**Parsons
Brinckerhoff**

from: Estine Archuleta
date: 4/22/99
time:
project: Vista del Norte
project number: 23445 TM, 3.1

Re: Vista Del Norte, DRB 98-78

Attached please find the revised Hydraulic Grade Line calculation sheets and a display showing the manhole locations and numbers in relation to the properties being developed by Mark Goodwin and Associates. The outfall for Tract I, Los Prados Del Norte Subdivision, has been relocated from manhole #19 to manhole #32, see display. The other change reflected in the revision is the addition of three additional stubs to Tract W, Villa Del Valle Subdivision. Originally, one stub collected flows from Tract W. At the request of Mark Goodwin's office we added stubs at locations that worked for their design and sized the stubs to handle their flows. No additional flows were added nor removed from this segment. These changes will be reflected in a revised grading and drainage submittal to your office.

TITLE: **LOS PRADOS DEL NORTE**
GRADING AND DRAINAGE PLAN

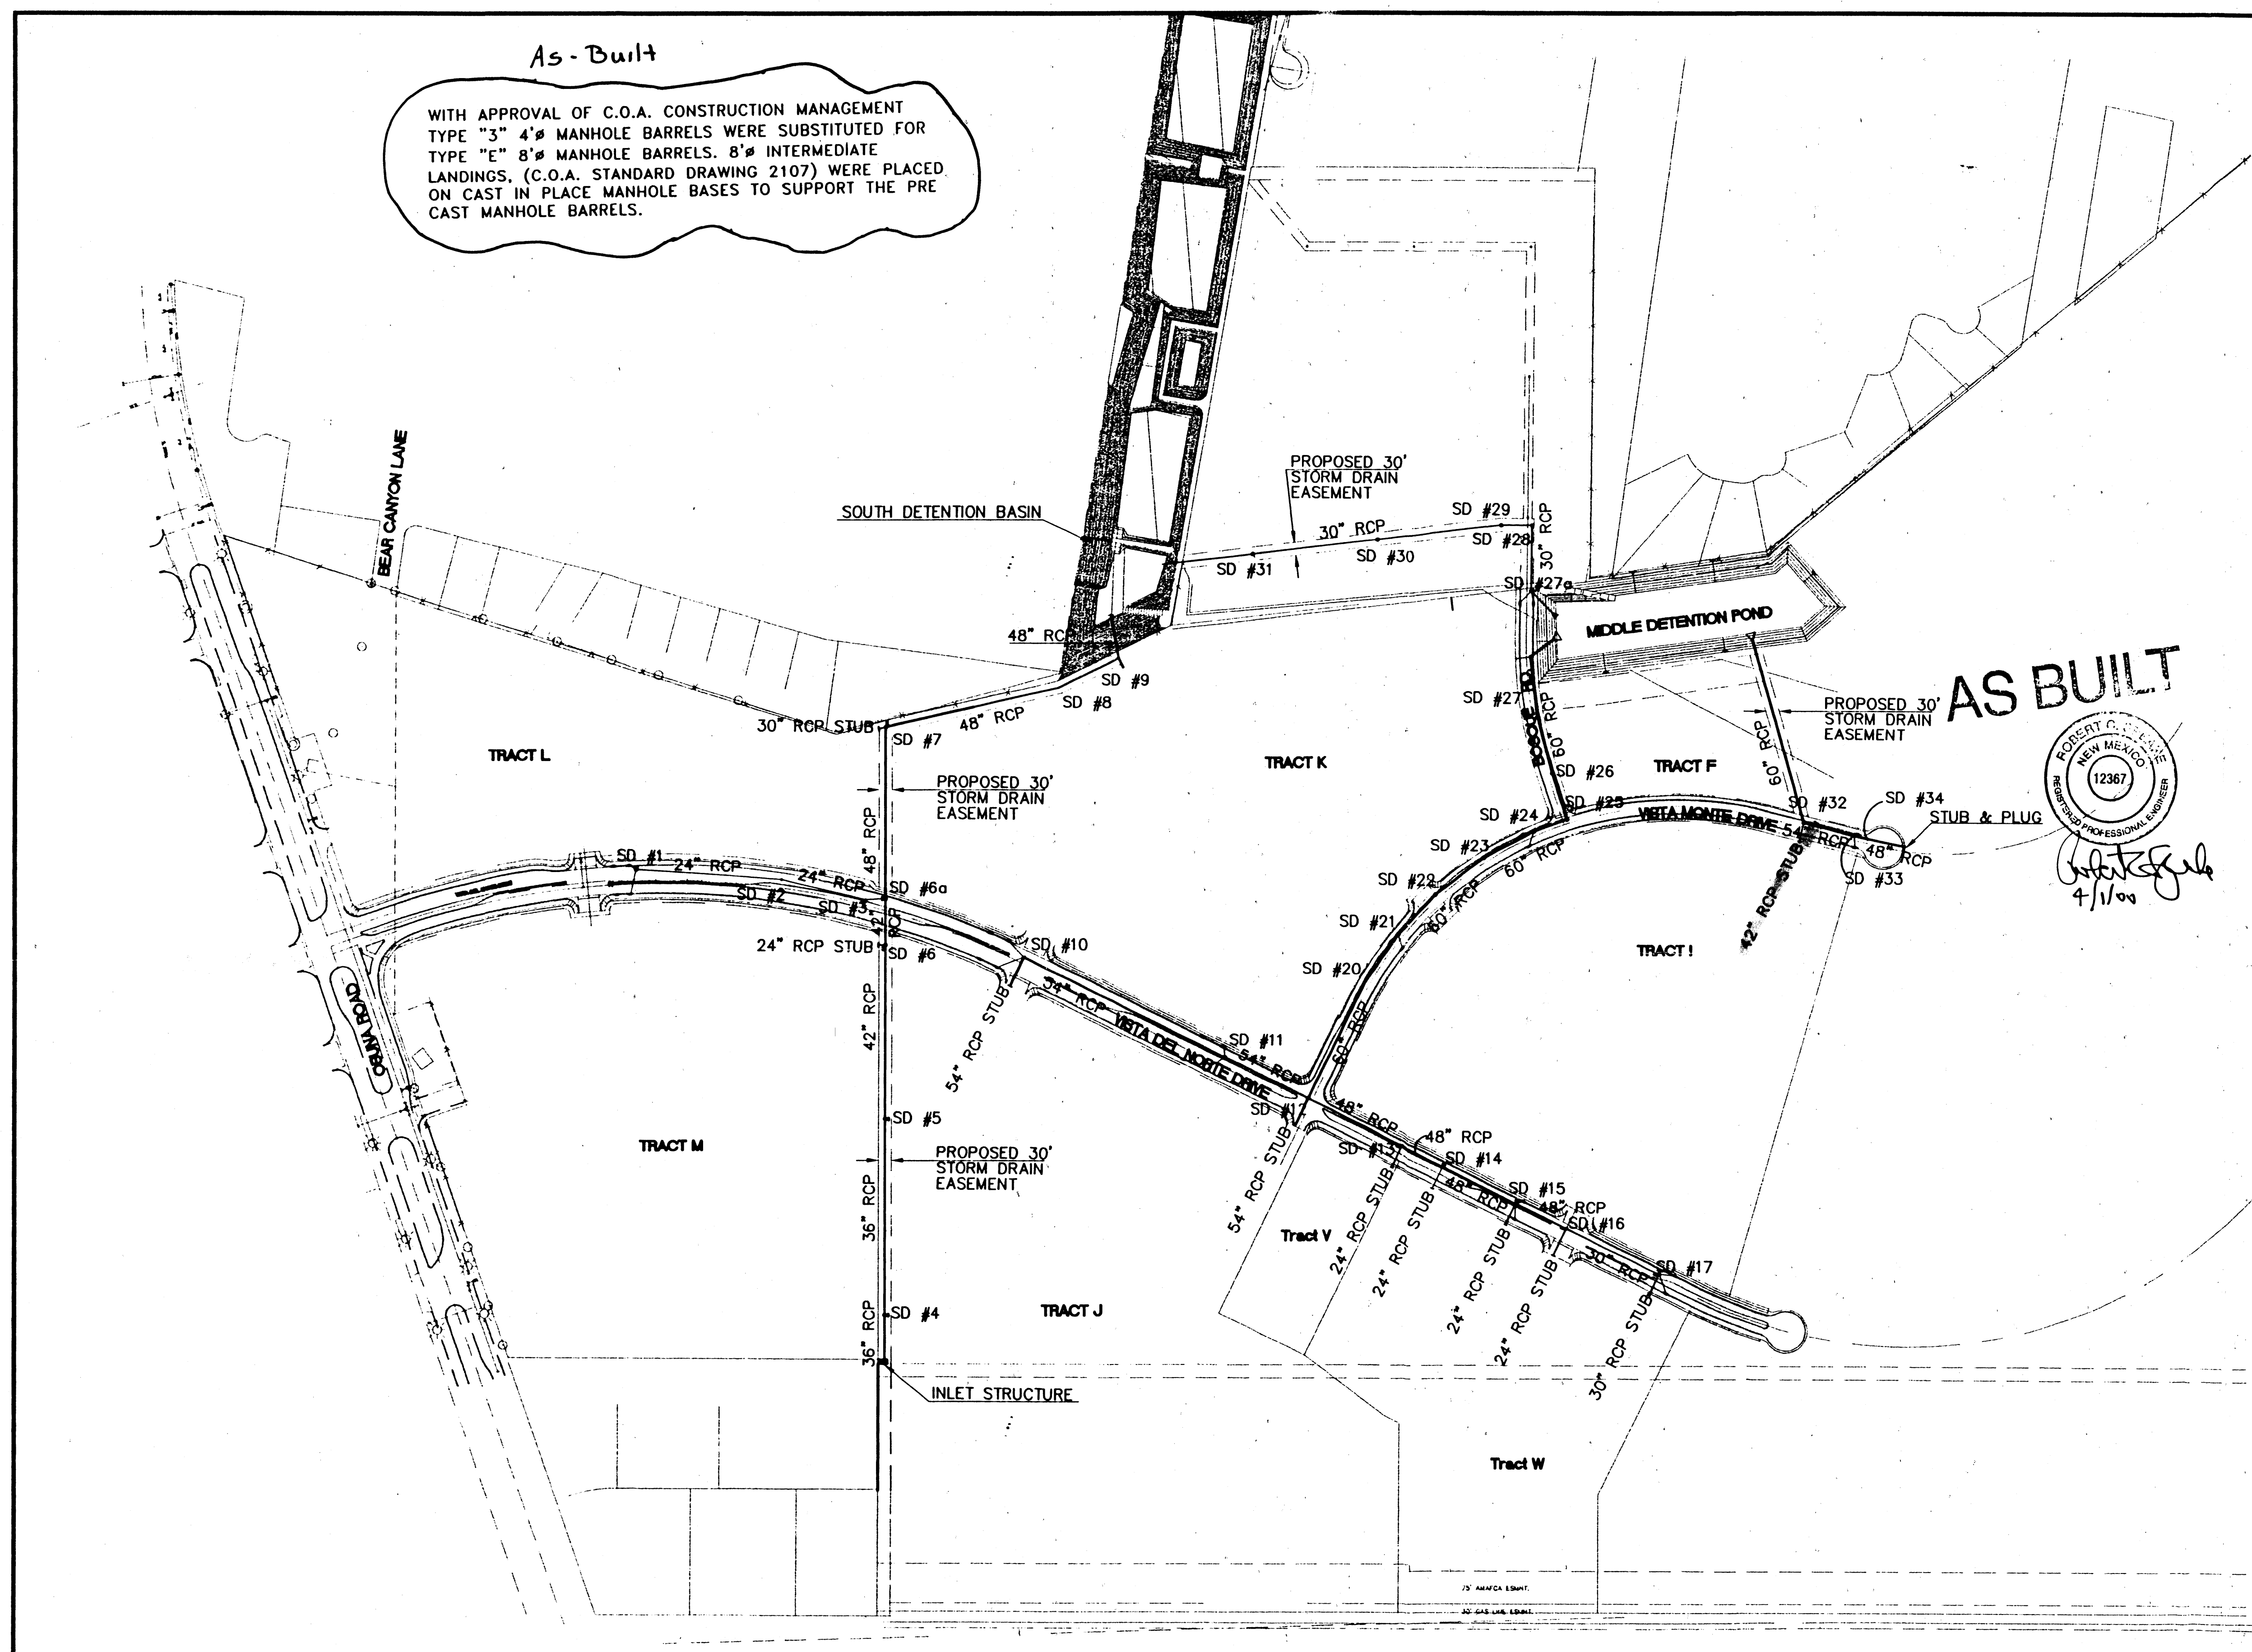
2. The master plan shows half of your site draining to the 60" storm drain on Vista Monte Drive, then draining west on Bosque Drive, and the other half draining to the northwest corner of your site. Your plan shows the entire site draining to the northwest corner. Please demonstrate that the storm drains designed by the Vista Del Norte master plan can handle this change. Have the off-site storm drains been constructed?

3. The plan uses a 6' wide channel in the subdivision to convey street flows. If the streets are public, then the channel should be built to City standards (10' wide) for City maintenance.

4. With respect to the sump inlet calculations, please show the location of inlet # 4 on the storm drain layout (sheet 1 of 2). The grading plan must show that the proposed inlets don't conflict with the driveways.
